From: Sue Howell
Sent: 21 August 2014 15:51
To: Planning.Responses
Cc: Peter Cleveland
Subject: RE: Planning Consultation on: BR/140/14/PL

Comment from Greenspace

RE: Planning application MANOR HOUSE, 12 CHICHESTER RD, BOGNOR REGIS BR/261/13

Description of Works: Conversion of existing vacant listed building to provide 4No. flats. Demolition of single storey building at rear (north) and construction of single storey extension and separate 2 storey building to provide 5No. flats. Resubmission following BR/41/14.

CLIENT
CS PROPERTY AND CONSULTANCY LTD
 PROJECT
MANOR HOUSE, 12 CHICHESTER ROAD
BOGNOR REGIS PO21 2XE
 DRAWING TITLE
PROPOSED GROUND FLOOR PLAN
 SCALE
1/100 at A3
 REFERENCE
11332.11B

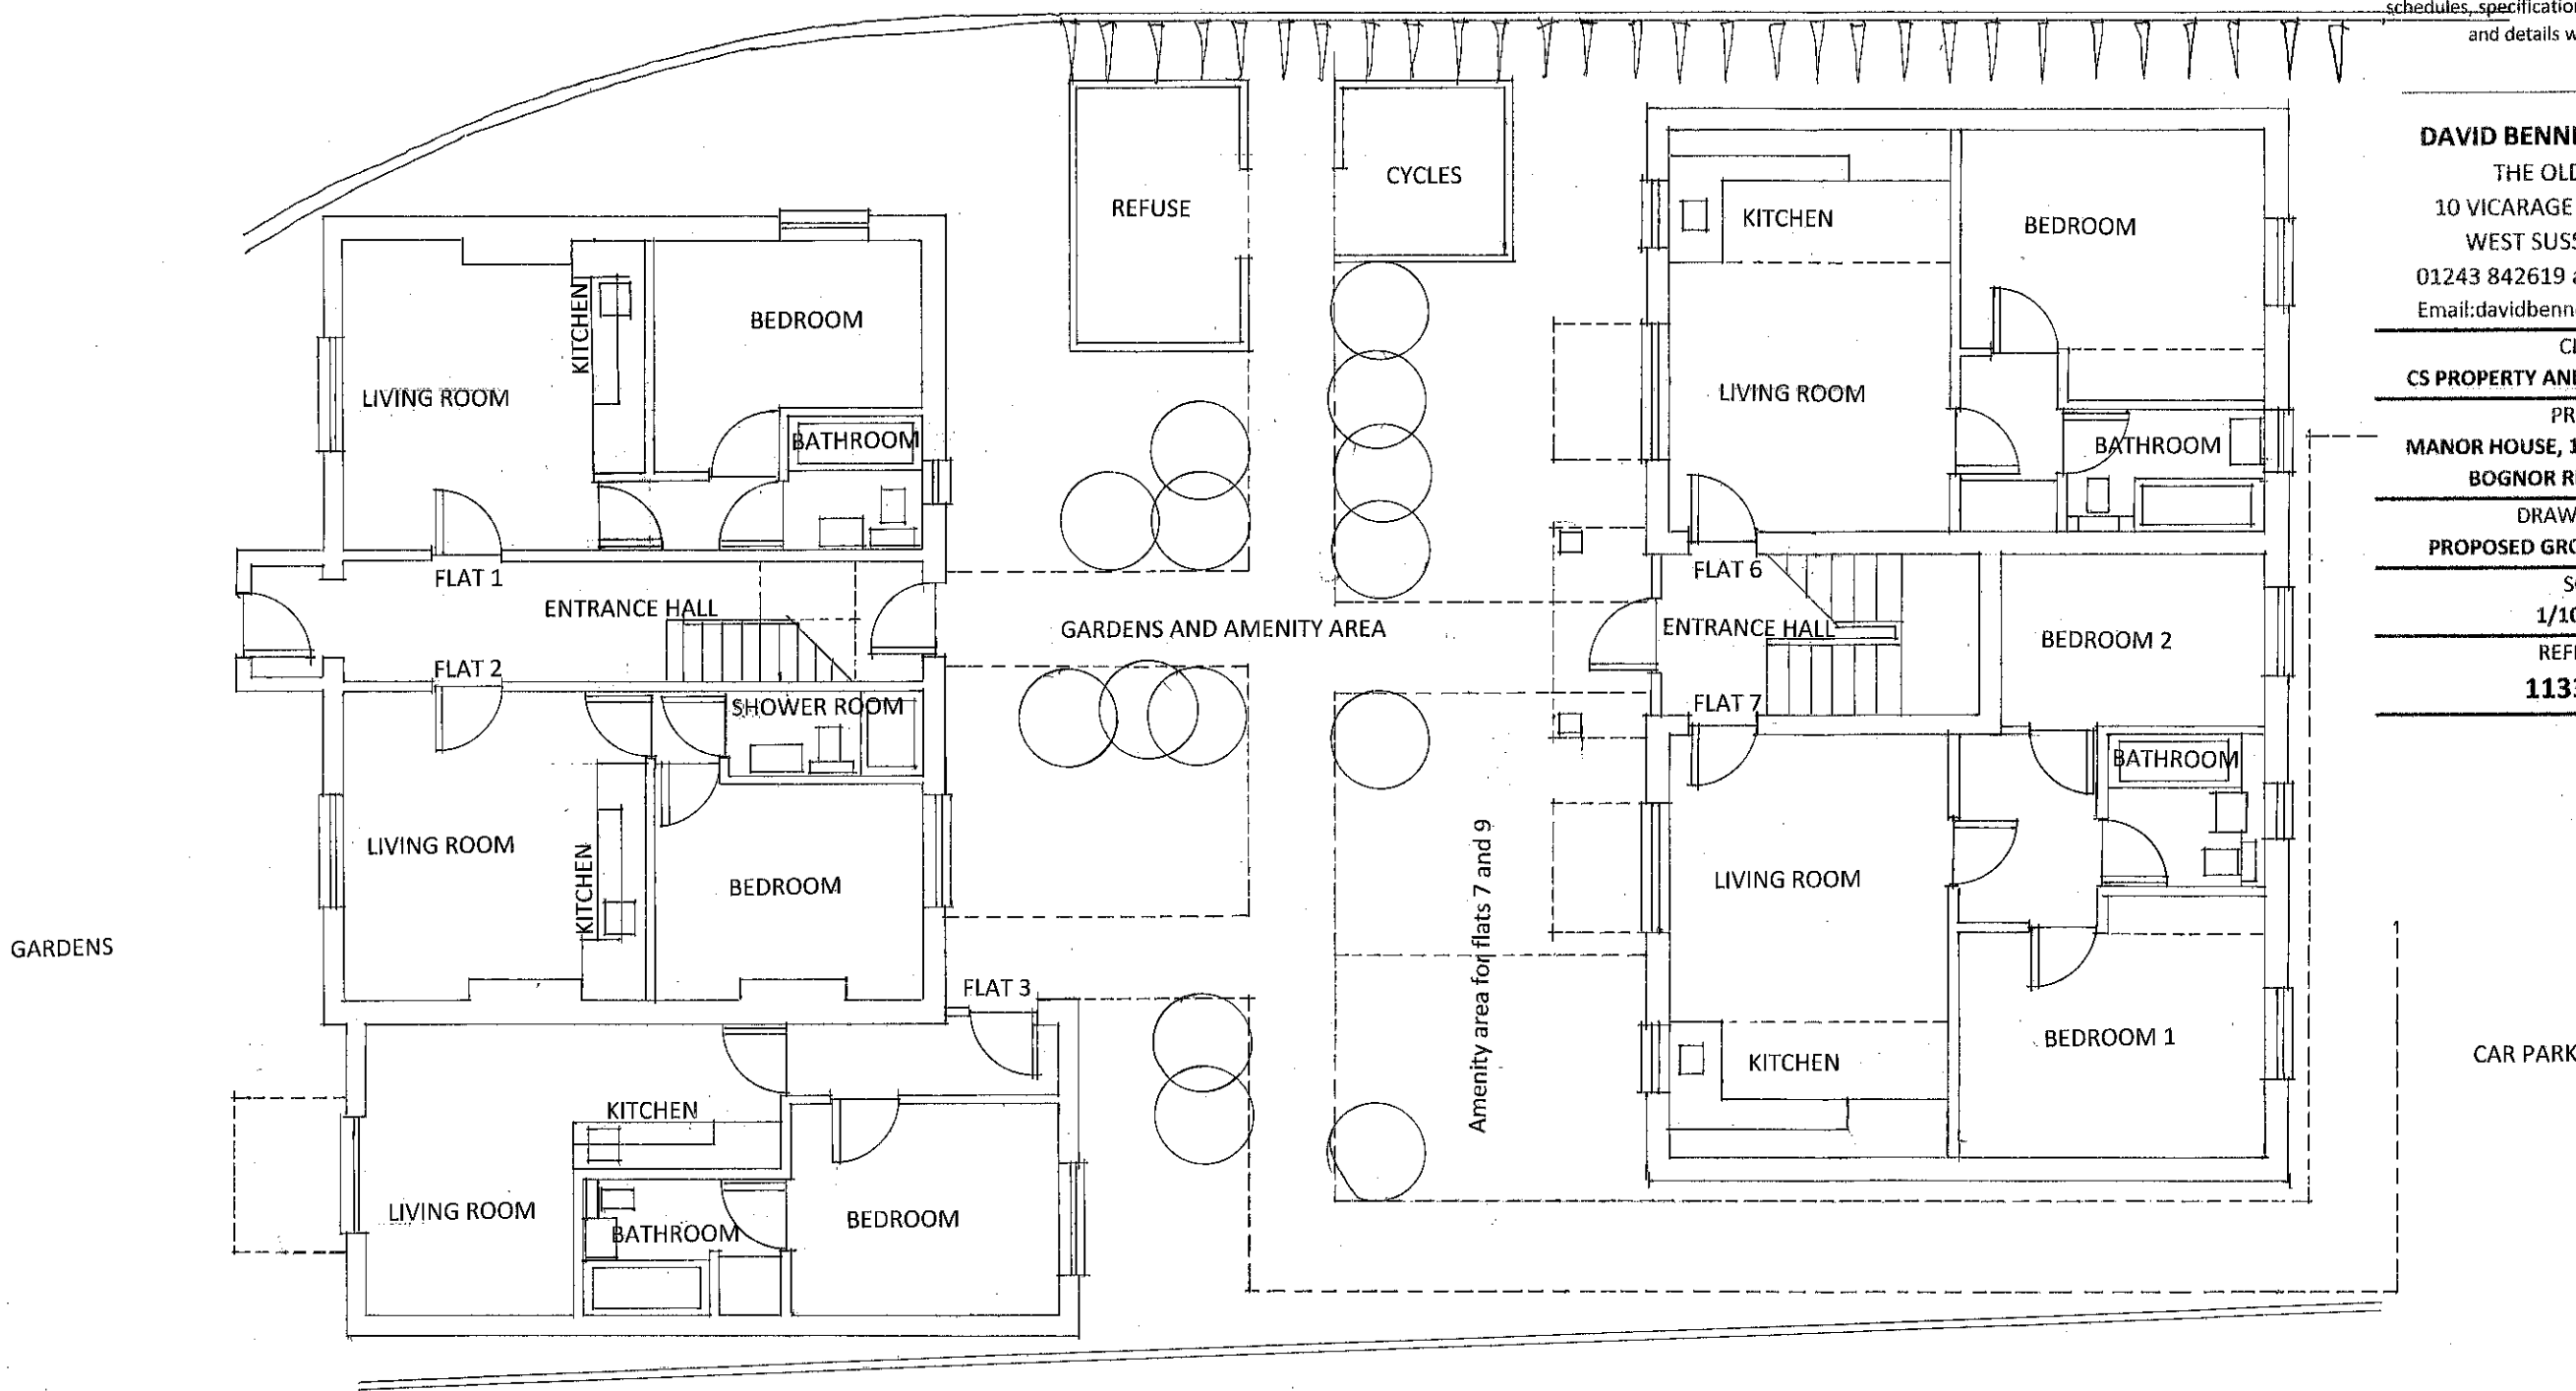
The perimeter coniferous tree cover to the western boundary does provide a degree of screening of the road, any trees shown for removal must be in consultation with Arun District Councils Tree Officer. The coniferous trees to the new access drive detailed to be retained will need to be particularly catered for during construction if they are to be retained without damage. We draw your attention to BS 5837:2012 'Trees in relation to construction' and the protection methods that this sets out. This is also relevant to any trees that adjoin from neighbouring properties.

The application states that the area to the south of the building will be restored to its original layout and details the provision of amenity space to the rear of the Manor House. We would recommend that detail of these are submitted in plan form to detail existing, and new planting proposals with quantities and species mix and size, with regard to suitability to this and neighbouring properties. These details should include any mitigation tree planting for the purpose of screening.
